Recommendation Report for Lawful Development Certificate for a Proposed Use or Development

REF NO: WA/12/13/CLP

LOCATION: Hatpins
Avisford Park Road
Walberton

PROPOSAL: Application for a Lawful Development Certificate for proposed front roof lights and rear dormer

Proposed first floor alterations
'Hatpins', Auisford Park Road, Walberton, BN18 0PJ
for Mrs Shintey Cleall

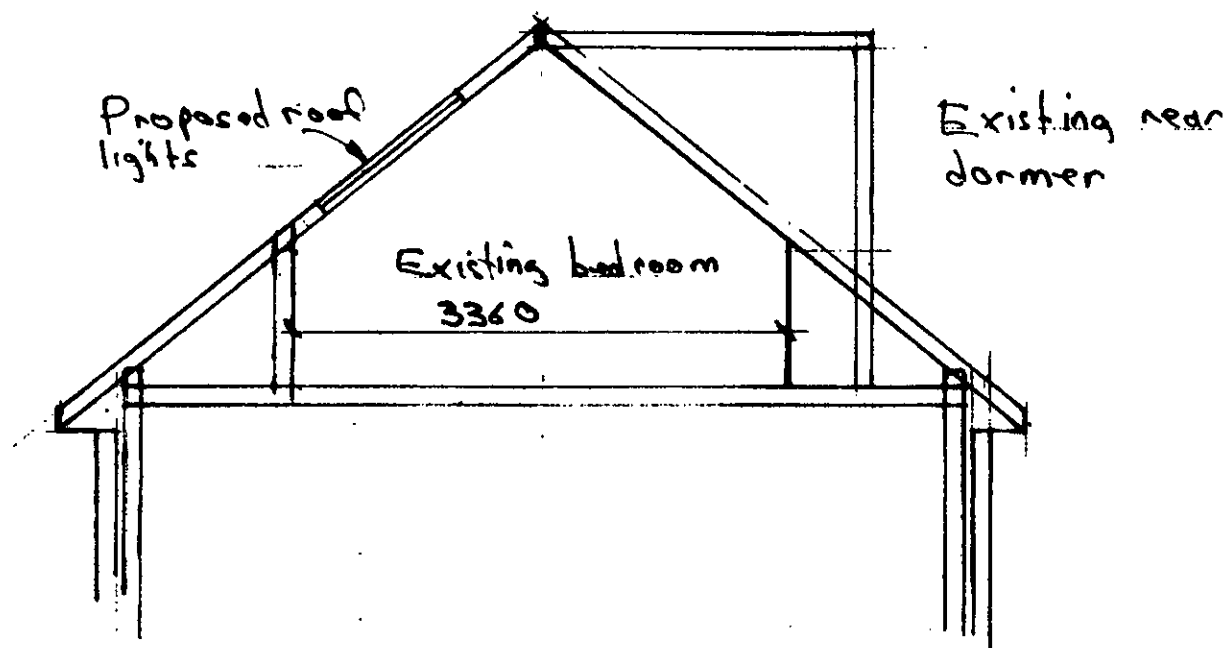
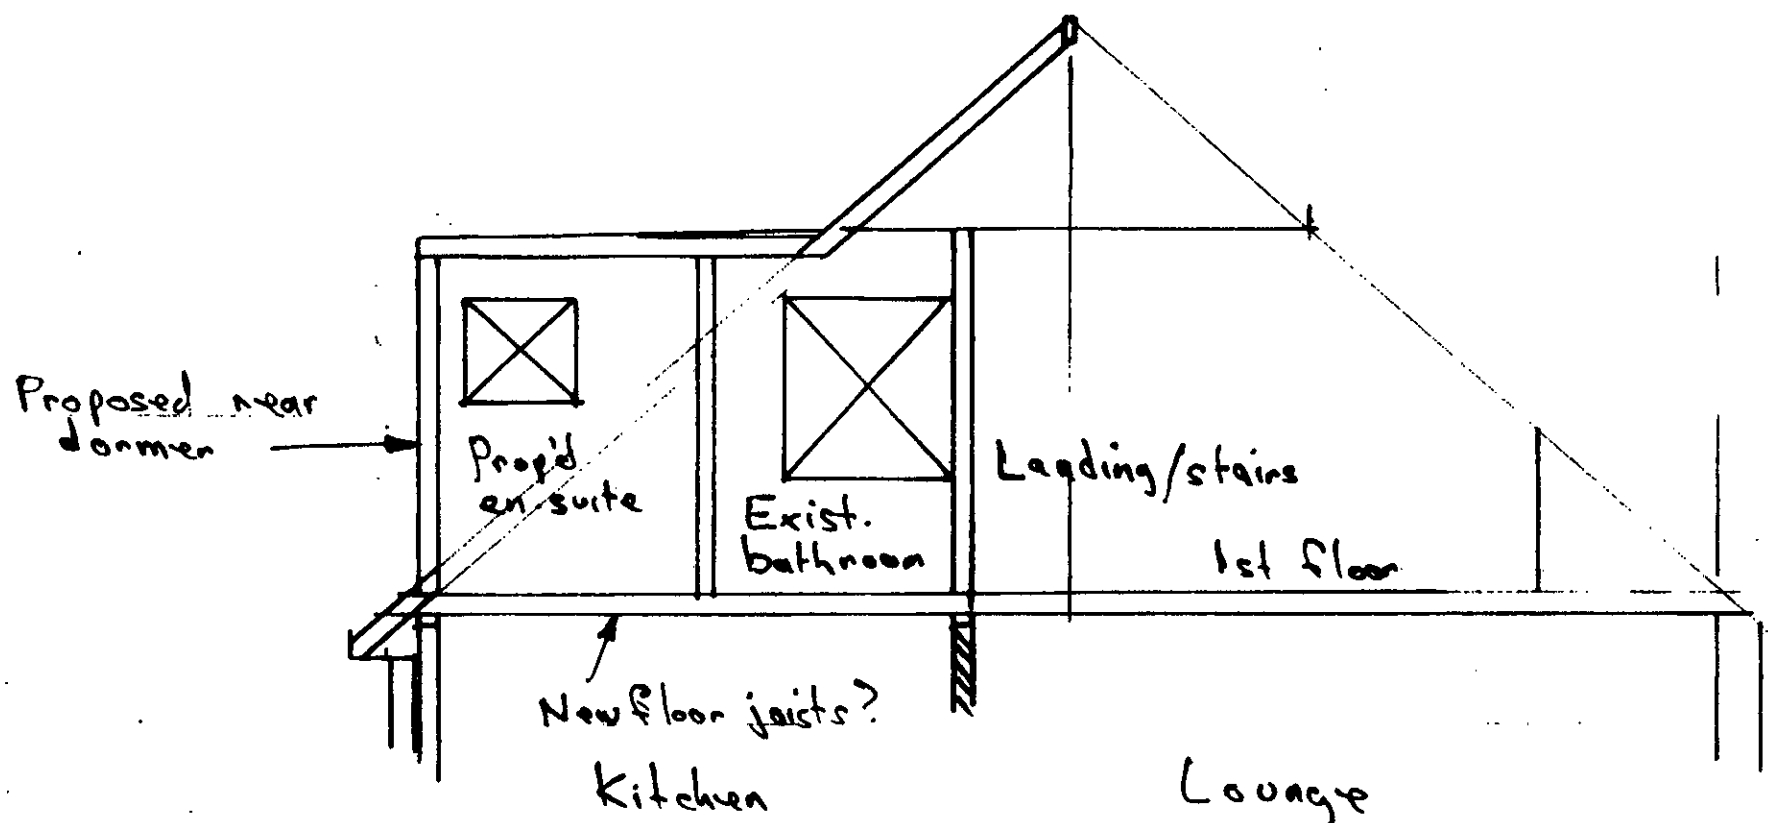
A further requirement that needs to be met in order for a roof extension to be classed as permitted development is that the edge of it closest to the eaves of the original roof shall, as far as practicable, be set at least 20cm from the eaves of the original roof. The accompanying plans show a distance of 20cm between the wall of the proposed dormer and the roof eaves and this confirms that the minimum distance is maintained.

Class C (a) allows for roof alterations, such as roof lights and sun pipes, to be installed provided they do not project more than 150mm from the plane of the roof slope. Accompanying sections show the roof lights to be flush with the plane of the roof slope, thereby satisfying this requirement.

PROPOSED ELEVATIONS

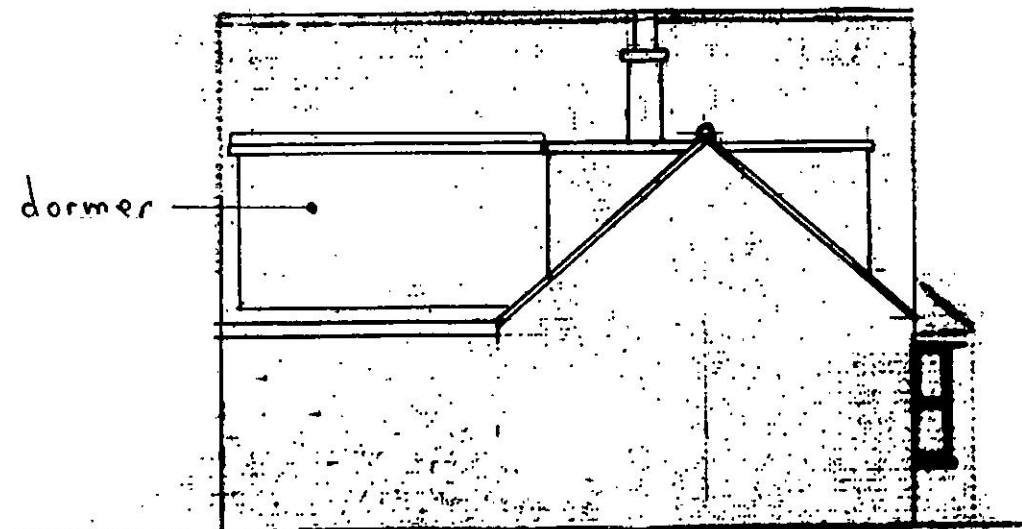
Criterion B.1 (a) states that a roof extension should not exceed the height of the existing roof. The top of the proposed dormer matches that of the existing building and, as such, this criterion is satisfied.

(b) informs that, for a roof extension to be deemed permitted development, it must not extend beyond the plane of any roof slope fronting a highway. The proposed dormer is to be installed on a side roof slope and would not project to the front, therefore, this criterion is satisfied.

The proposed dormer includes an eastern (side) facing elevation. There are restrictions on the form of windows and openings that can be made in a side facing elevation of a dormer. However, the proposed dormer will not contain any side facing windows and, as such, these restrictions are not applicable.
